Our ref: NO/2015/107923/03-L01
Your ref: 3/2015/0462
Date: 19 October 2015

DEMOLITION OF INDUSTRIAL STORAGE BUILDINGS TO THE REAR OF 19-21 KING STREET AND REGENERATION OF THE SITE TO PROVIDE 3 NO. TWO-STOREY DWELLINGS - ONE DETACHED AND ONE PAIR OF SEMI-DETACHED 19-21 KING STREET, WHALLEY

3980 - 04A.

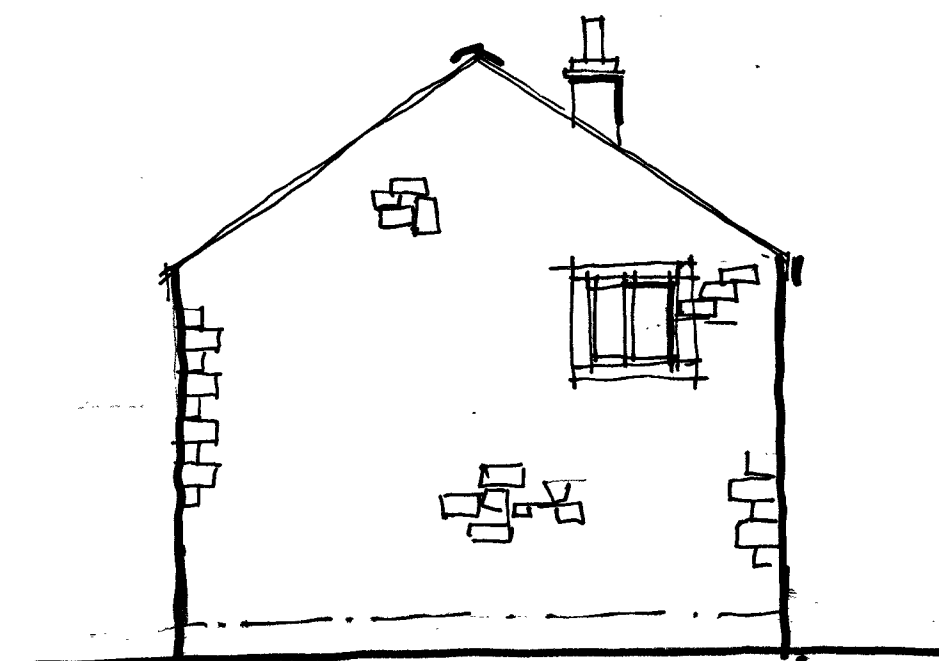
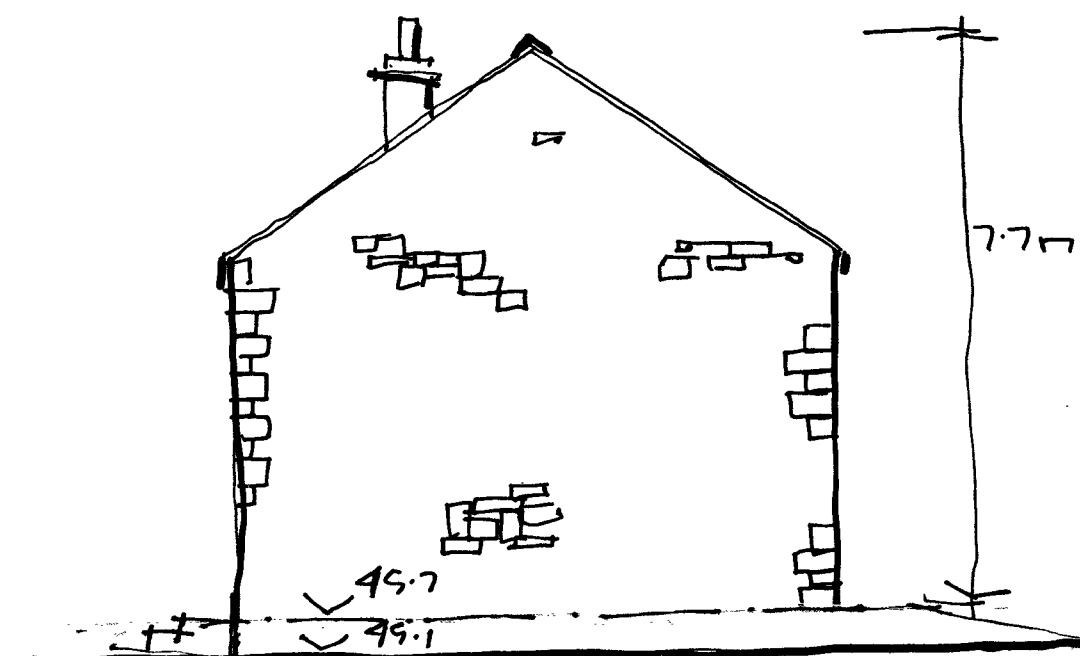
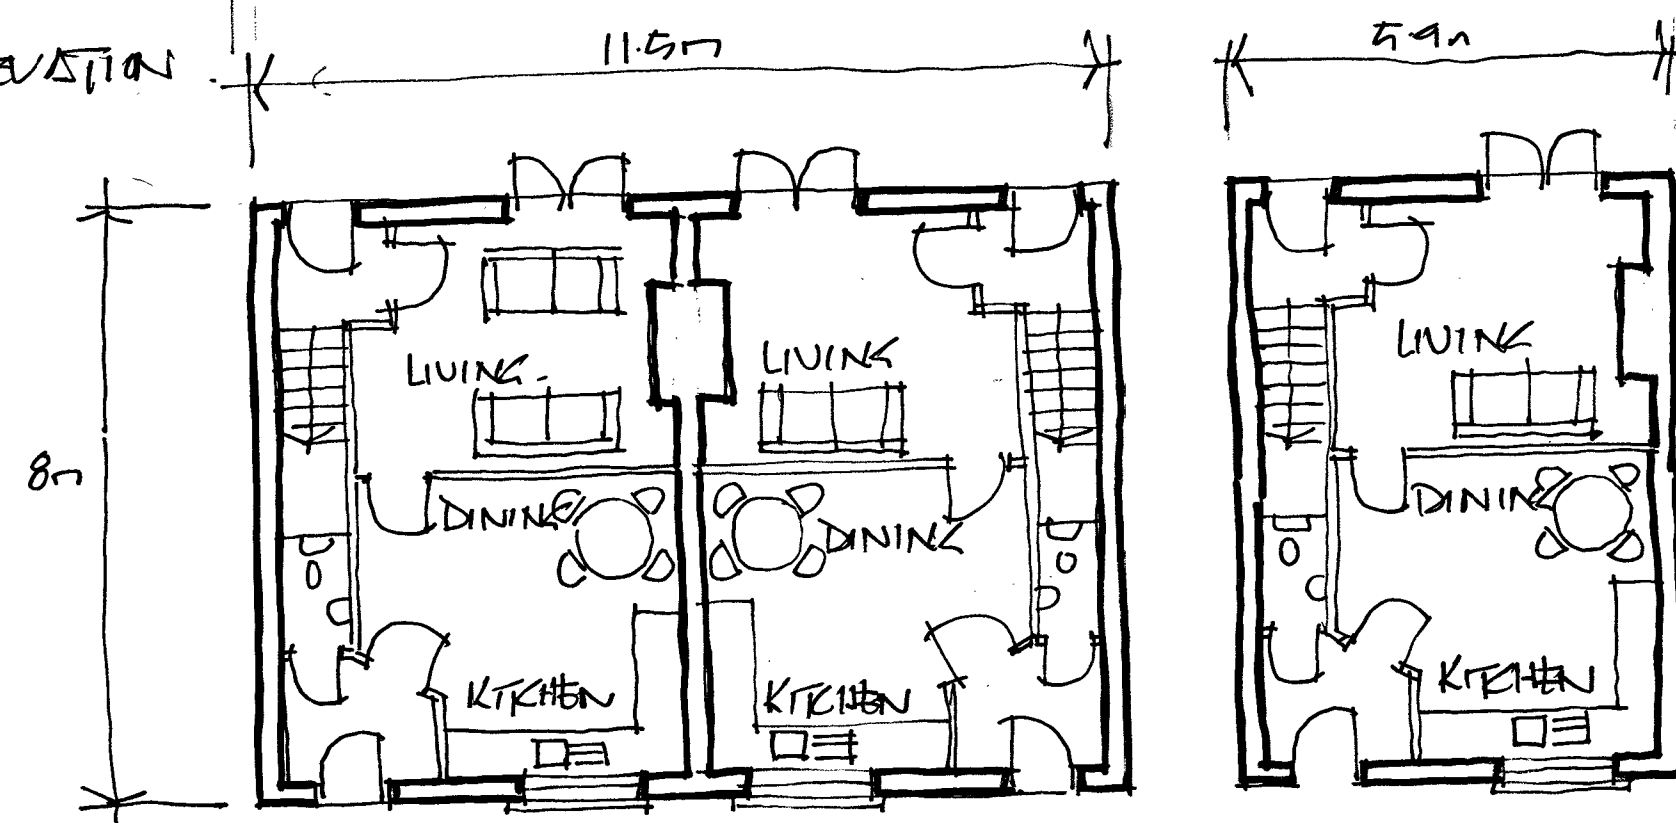
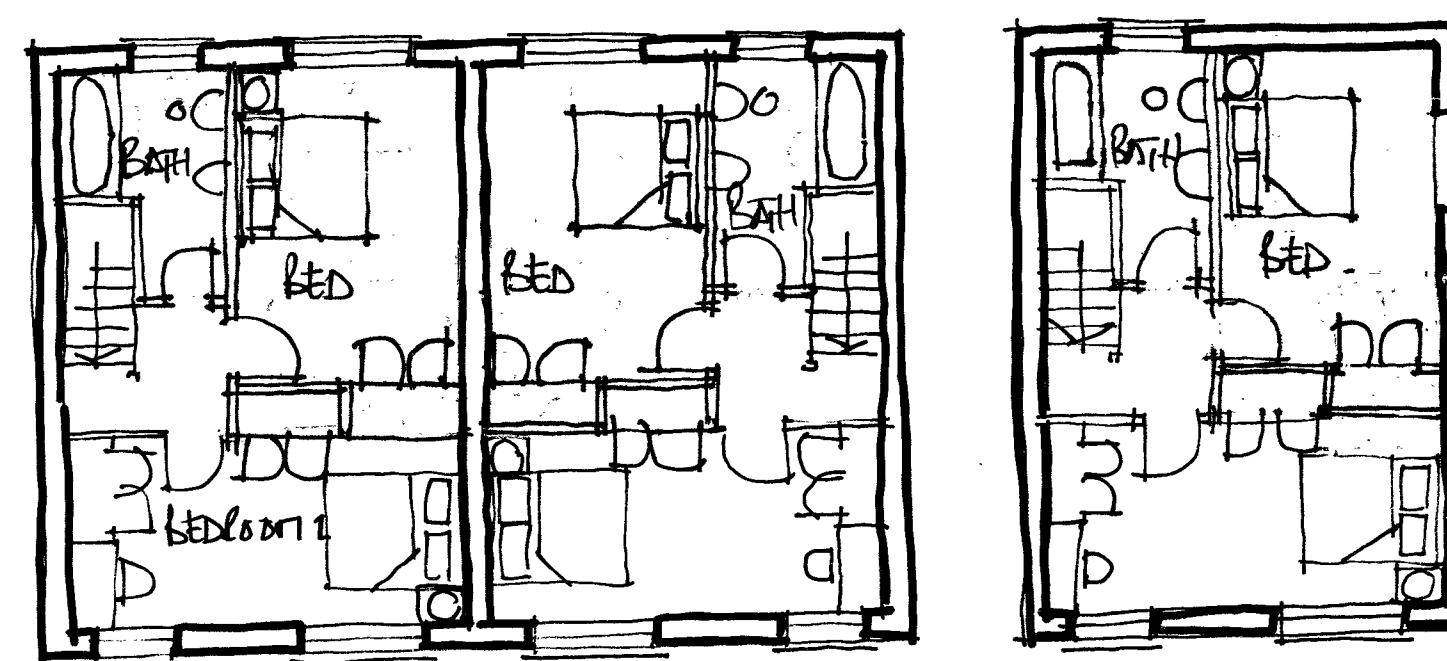
1. Finished floor levels are set no lower than 45.7m above Ordnance Datum (AOD).
2. Floors should be of solid construction and flood resilient construction techniques should be used.
